**RE: Shed permit - 15 Winter St.**

**From:** Christina Stacey [<mailto:cstacey@portlandmaine.gov>]  
**Sent:** Friday, January 22, 2016 12:10 PM  
**To:** [mstockford@maine.rr.com](mailto:mstockford@maine.rr.com)  
**Subject:** Shed permit - 15 Winter St.

Plot Plan

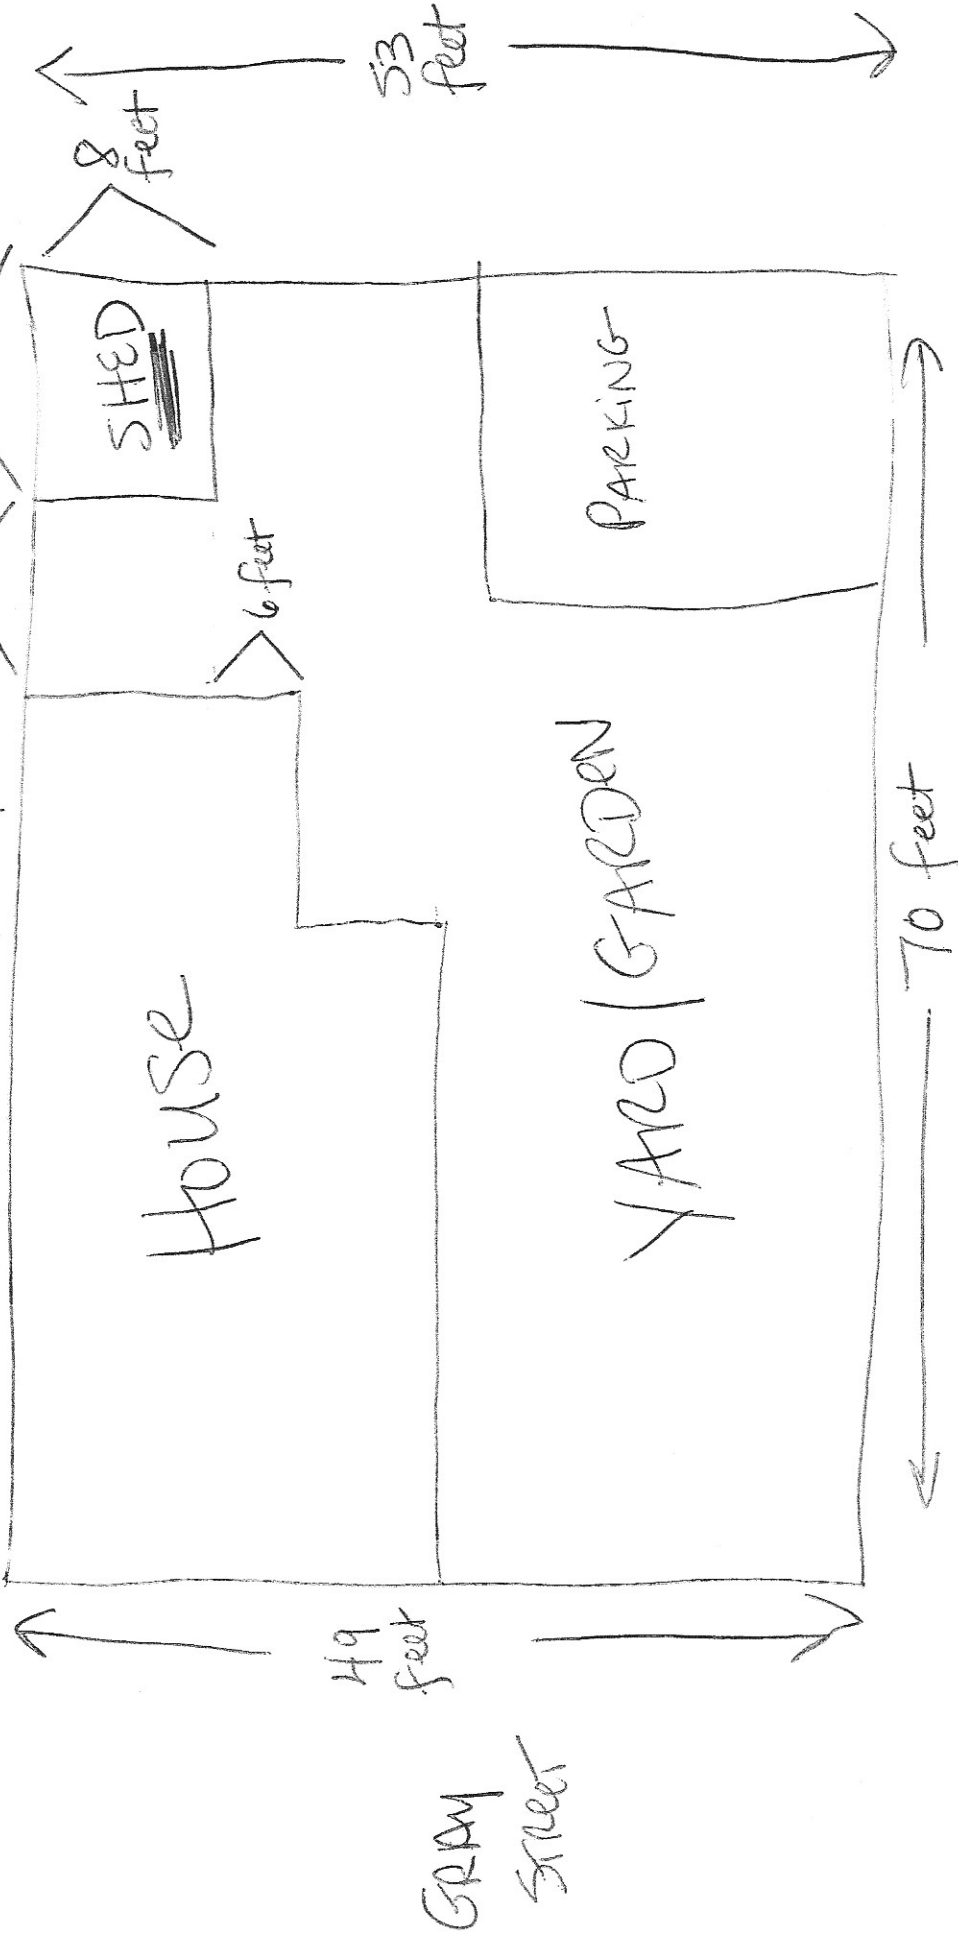
There is a provision that allows a property line setback as low as 2 feet from side & rear lines, but it requires that the shed be at least 15 feet from any nearby residential buildings, so I am not sure if it helps too much. I am attaching the relevant section of the ordinance so you can read the language of it, see items (a) and (b) at the top of the page. Let me know if you have any questions.

I am reviewing your application for a shed to be placed at 15 Winter St. Unfortunately it does not appear the project meets our required setbacks of 5 feet from the side and rear property lines. Is there a location on the property where the shed can meet these setbacks?

I have attached my official proposed location for a 6 x 8 foot shed on my property. (The scale of the drawing is 1 inch = 10 feet.) This location and size has been approved by Rob Wiener in the Historic Preservation Office. As can see, I have sited it 5 feet from each of my property lines.
